PORTLAND MAINE

October 14, 2004

RE: Capricorn Products Change of Use, 1 Rice Street
ID #2004-0040, CBL #354-A-003

SD-1

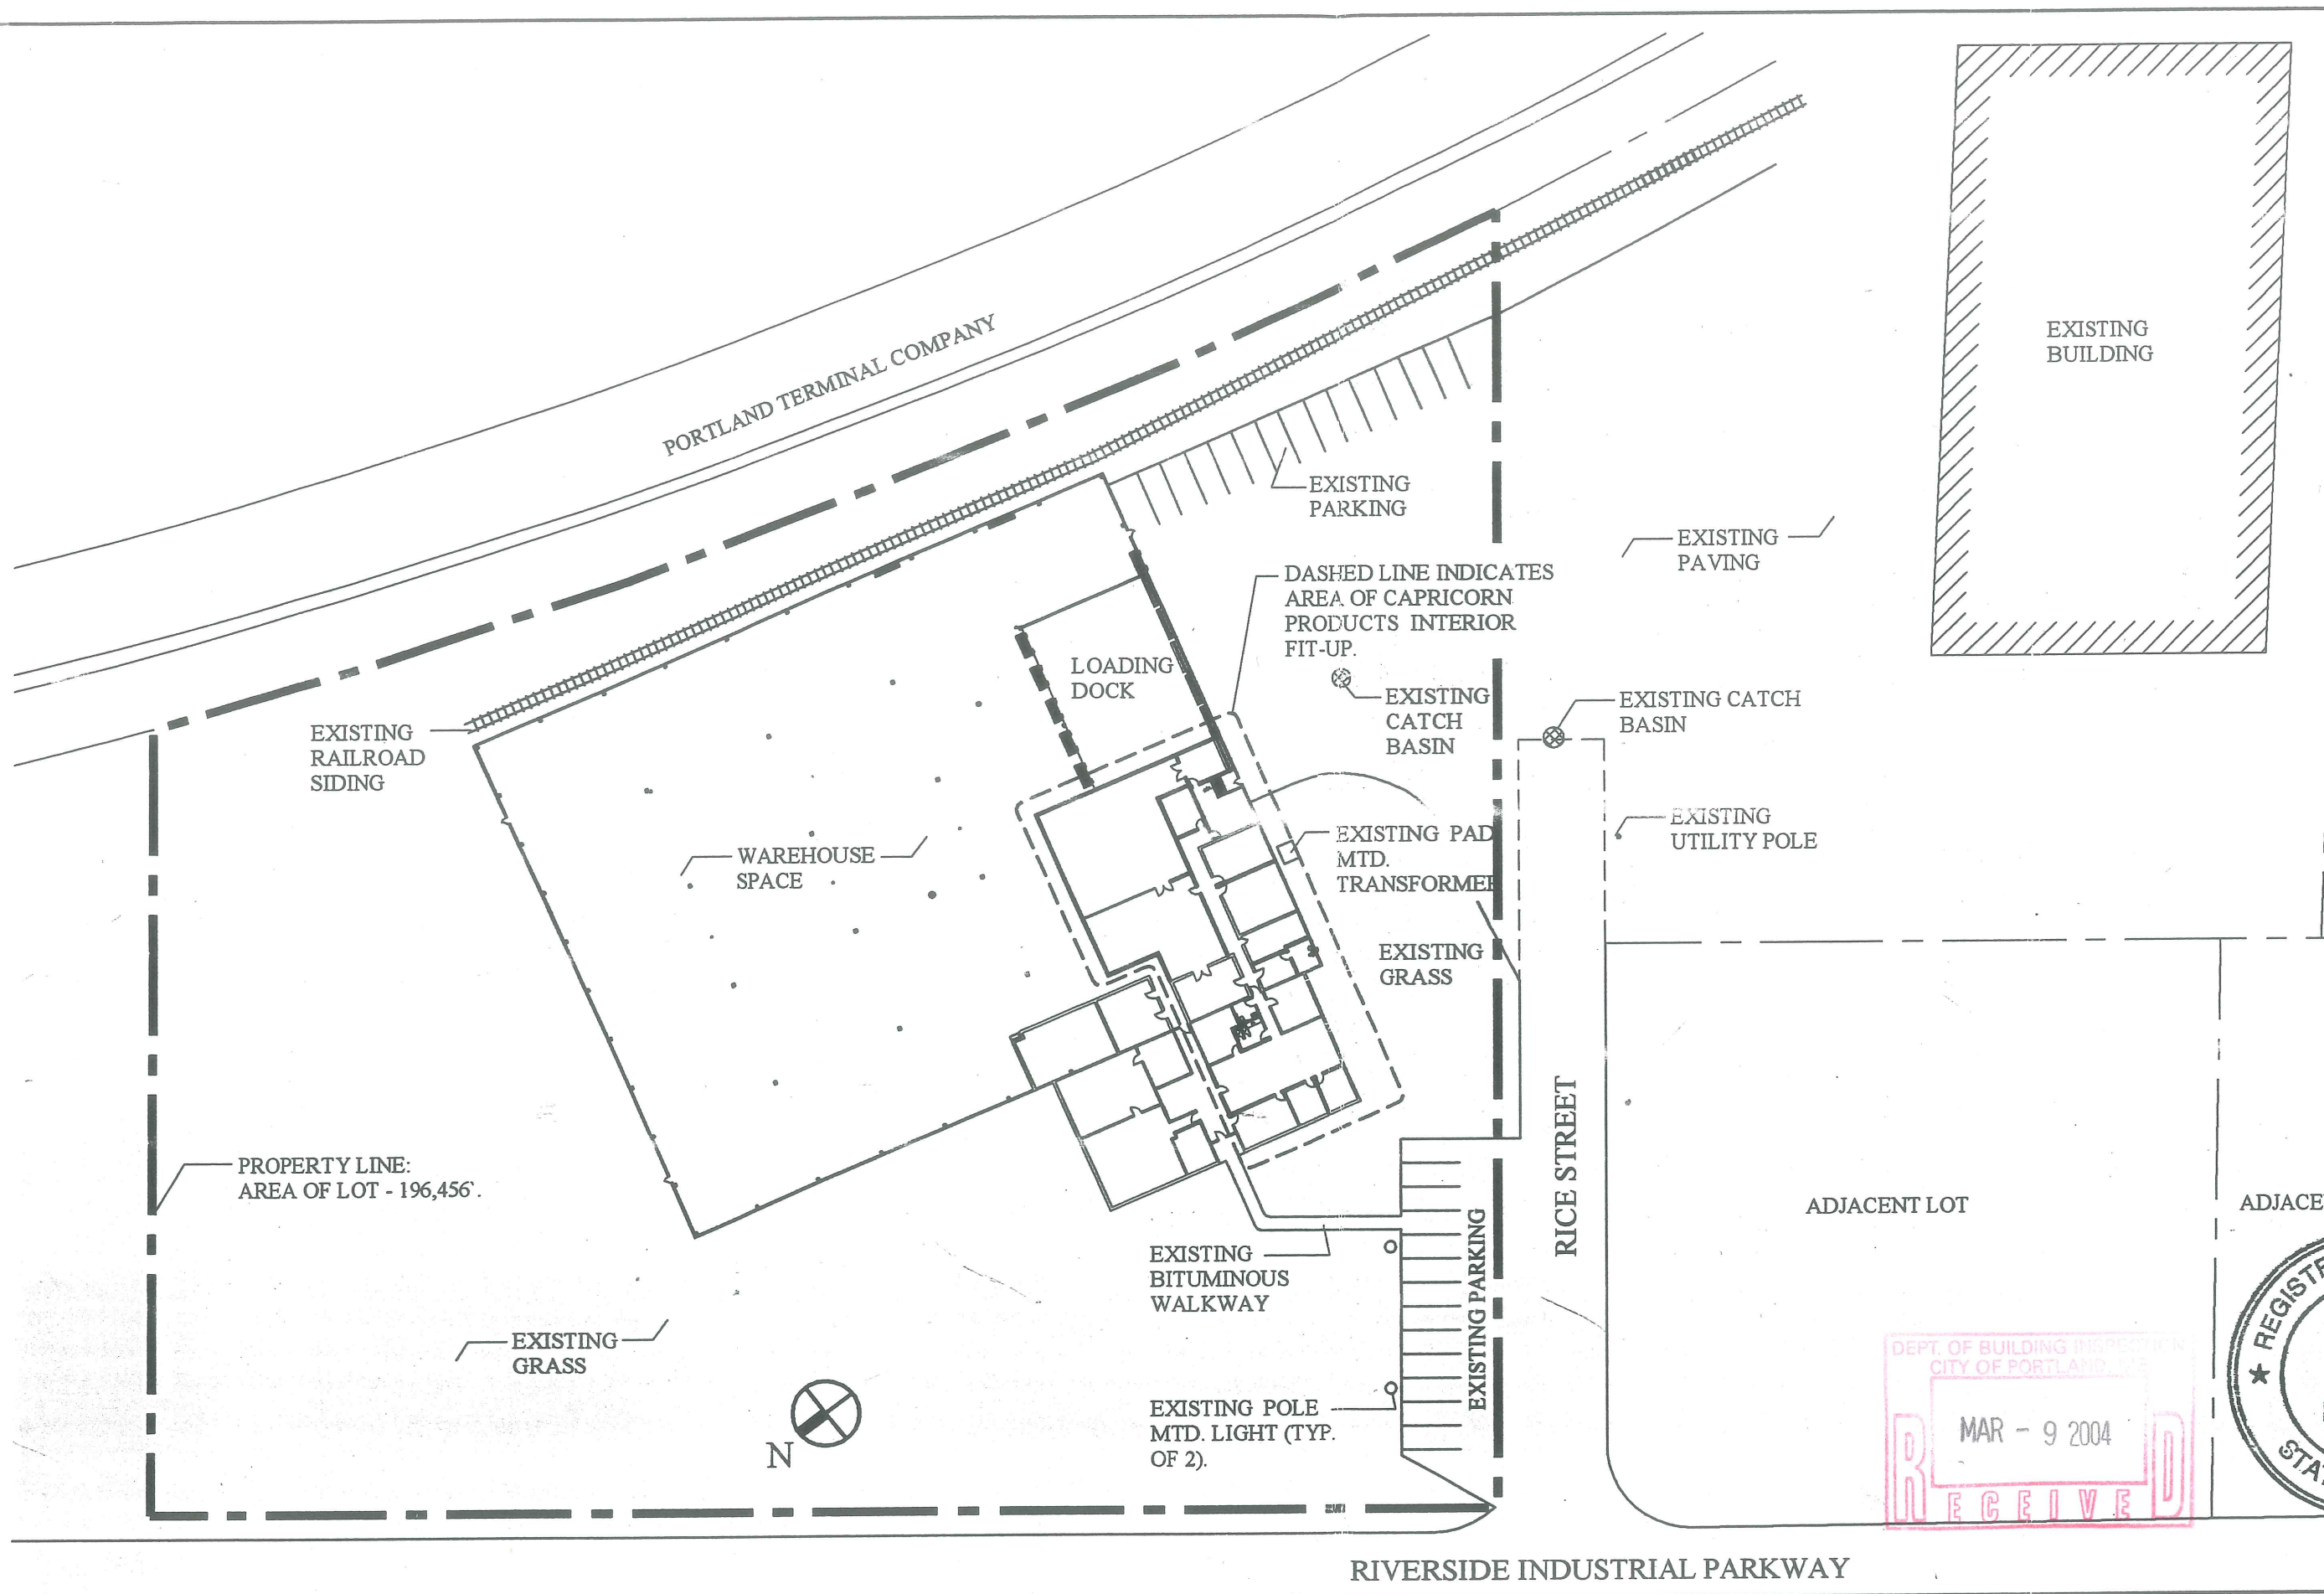
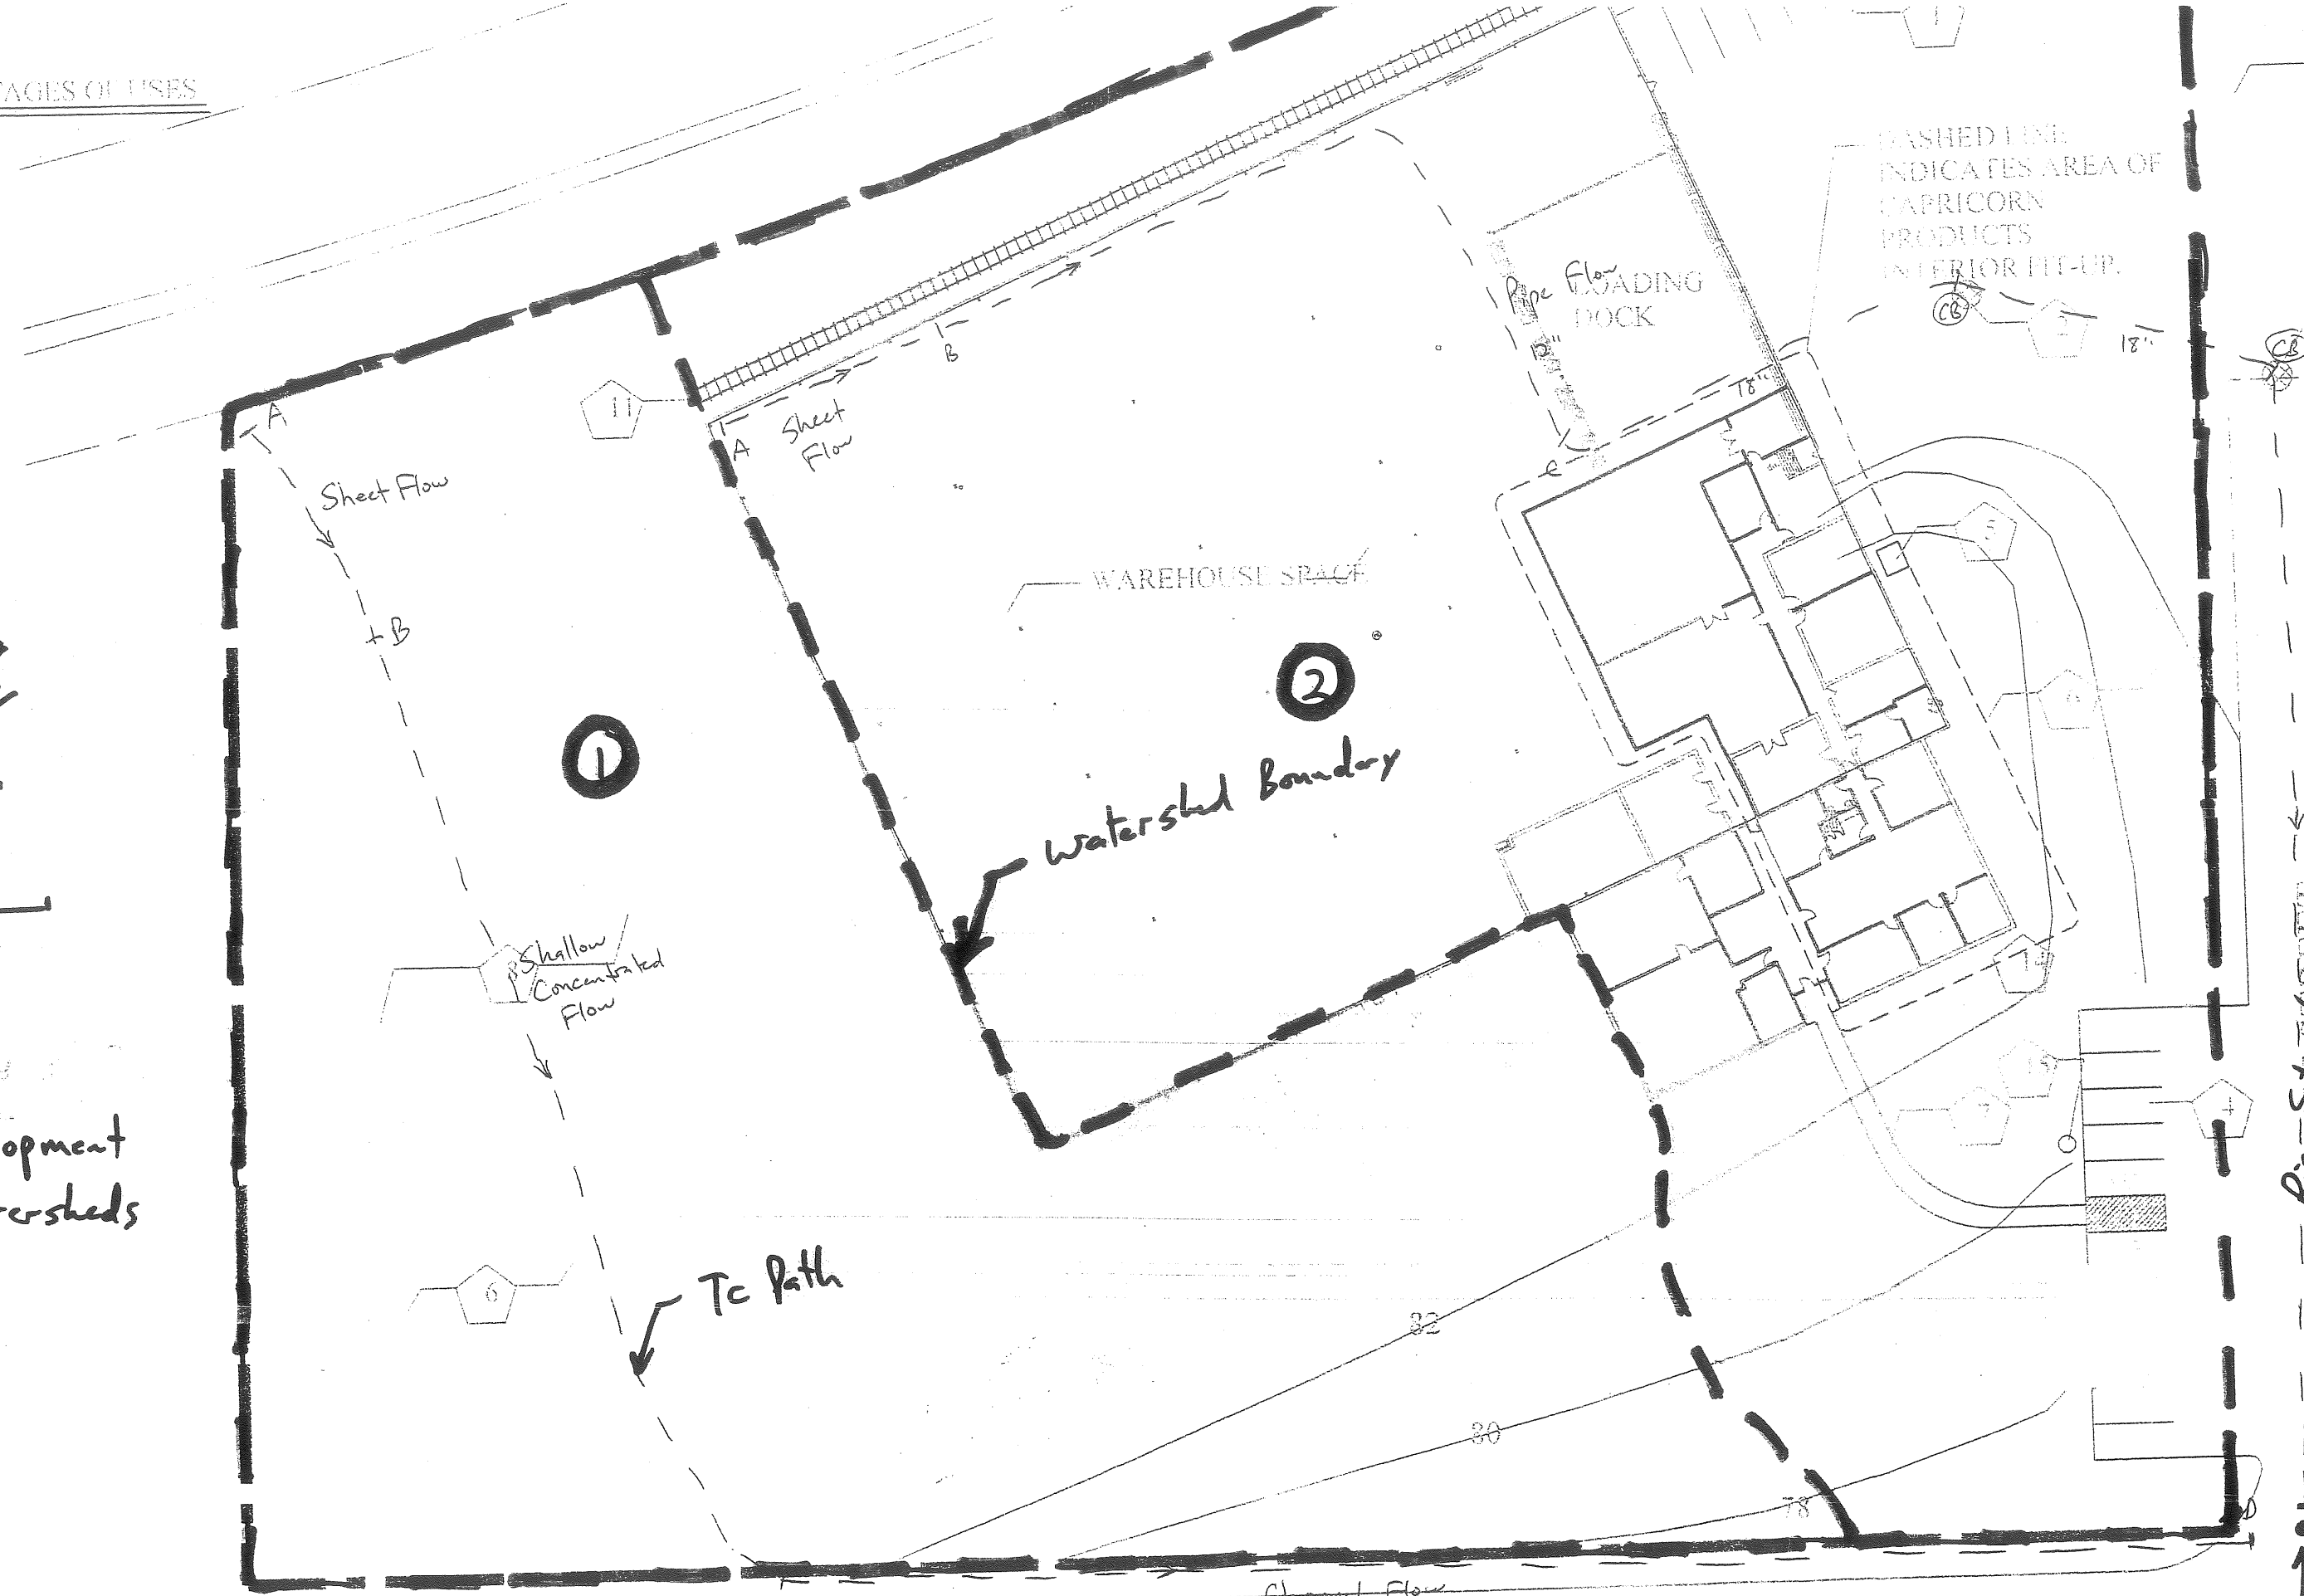
After a recent site visit, it has come to our attention that the development of the site is not in compliance with the approved site plan.

As part of the site plan approval, you were required to provide 63 parking spaces on site. The approved site plan showed 15 existing parking spaces and an additional 50 parking spaces were to be constructed, for a total of 65 parking spaces. However, the 15 parking spaces shown as existing, are not striped and are being used for outdoor storage and only 42 additional parking spaces were constructed.

To bring your development into compliance, you must stripe the 15 parking spaces on the westerly edge of the pavement near the loading docks and you must construct an additional 6 parking spaces to meet the 63 parking spaces required by zoning.
